From: Martin Farrer [REDACTED]
Sent: 14 December [REDACTED]
To: Amber Willard
Cc: 'Clive Matthews'; 'Juliet Matthews'
Subject: RE: Gulls, 7 Second Avenue, Felpham - FP/182/20/HH
Attachments: 3249_P_01A - proposed plans.pdf; 3249_P_02A - proposed elevations.pdf; 3249_P_04 - addressing measures to prevent overlooking.pdf

FP/182/20/HH at Gulls, First Avenue.

Job No: 3249
Dwg No: P_04

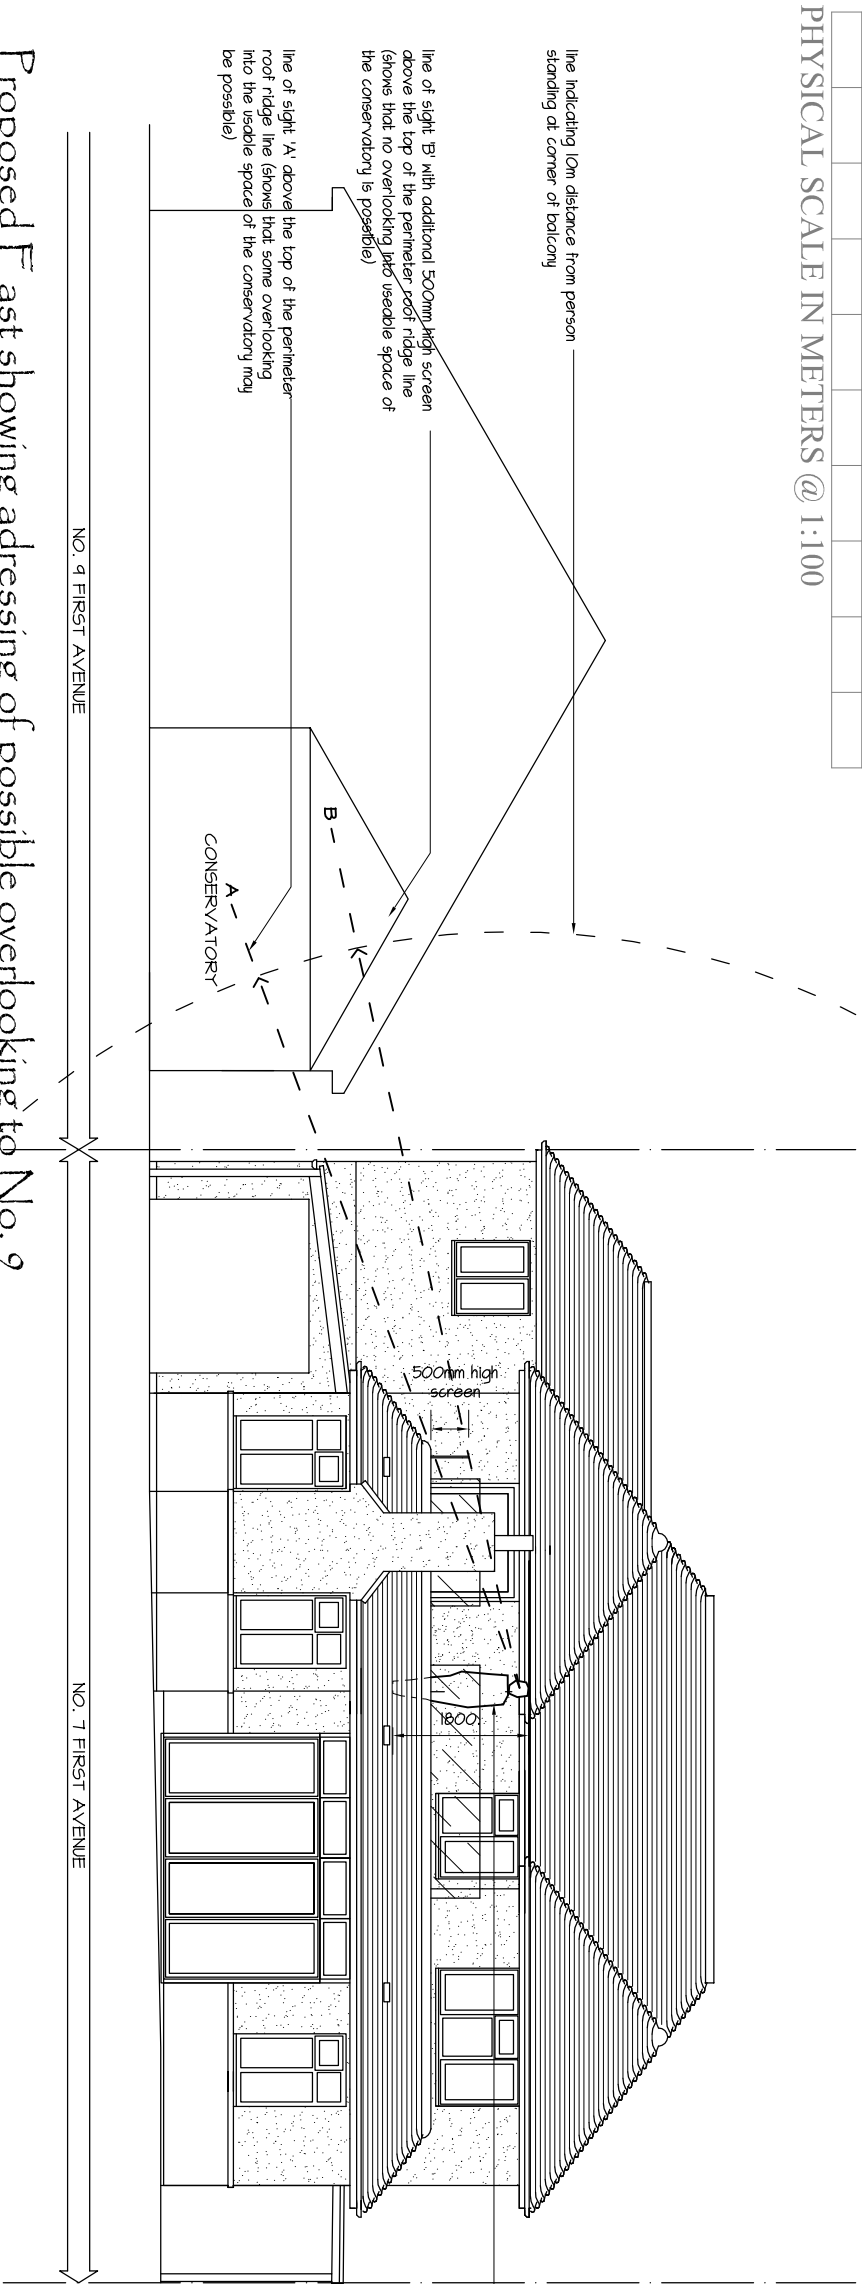
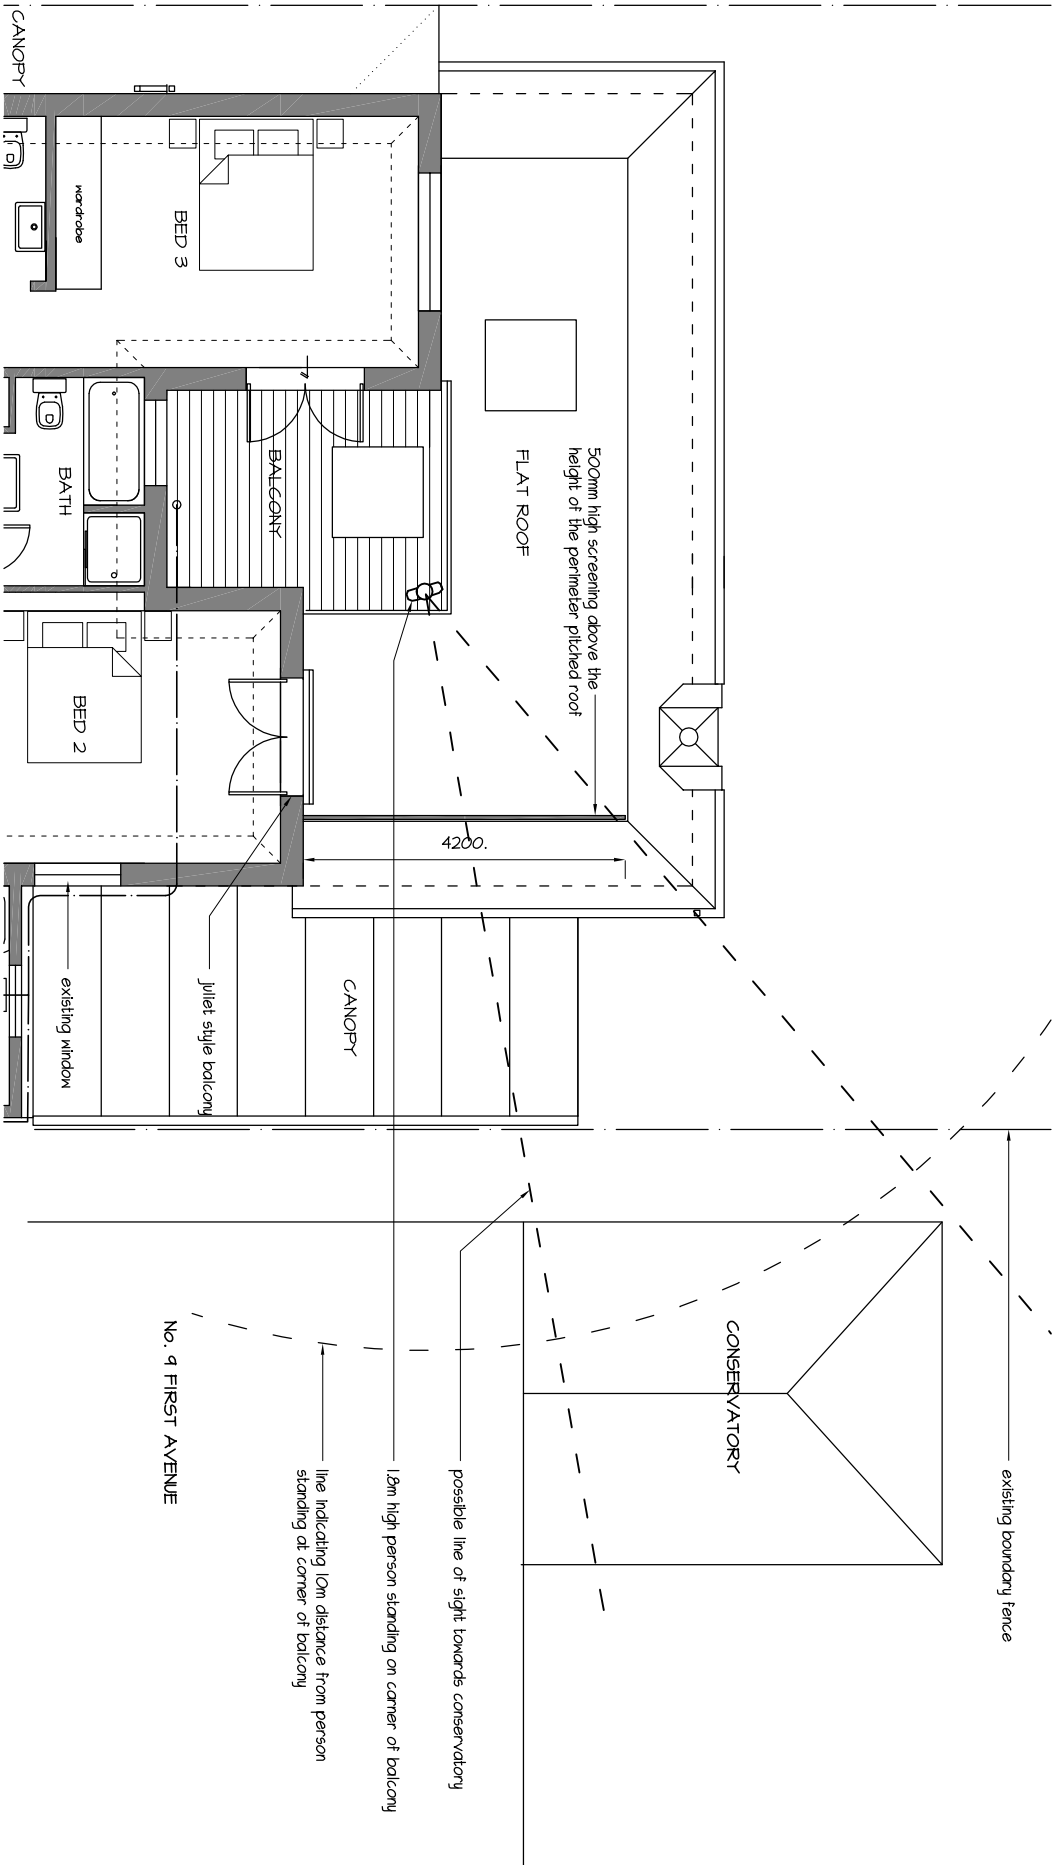
'I don't think the view from the smaller balcony would be more harmful than the adjacent window. It would be helpful if the agent could indicate on a plan a person of 1.8m height at the very corner of the new balcony and a line to show what they could view when looking to the conservatory. It might be necessary to have a small screen still on the very edge of the roof.'

Are you able to provide a sketch to demonstrate possible views.

I have now prepared a new drawing as requested to show a 1.8m high person standing on the corner of the proposed balcony to show possible overlooking concerns to the neighbour's conservatory, as attached drawing P_04. I have also shown an indication of the distance of 10m, to gauge the distance of possible views.

This has shown that there may be a possibility of overlooking, as shown with line 'A' with the existing scheme. To address this possible concern, I have therefore suggested the addition of a small privacy screen at 500mm high along the top of the ridge to the perimeter pitched roof along the south elevation only. With this screen in place the new line of sight is shown by sight line 'B'. This indicates that the screen would prevent any possible overlooking into the conservatory, and therefore addresses the concerns raised. With the height at 500mm it also allows for views above and into the distance towards the sea for the applicants.
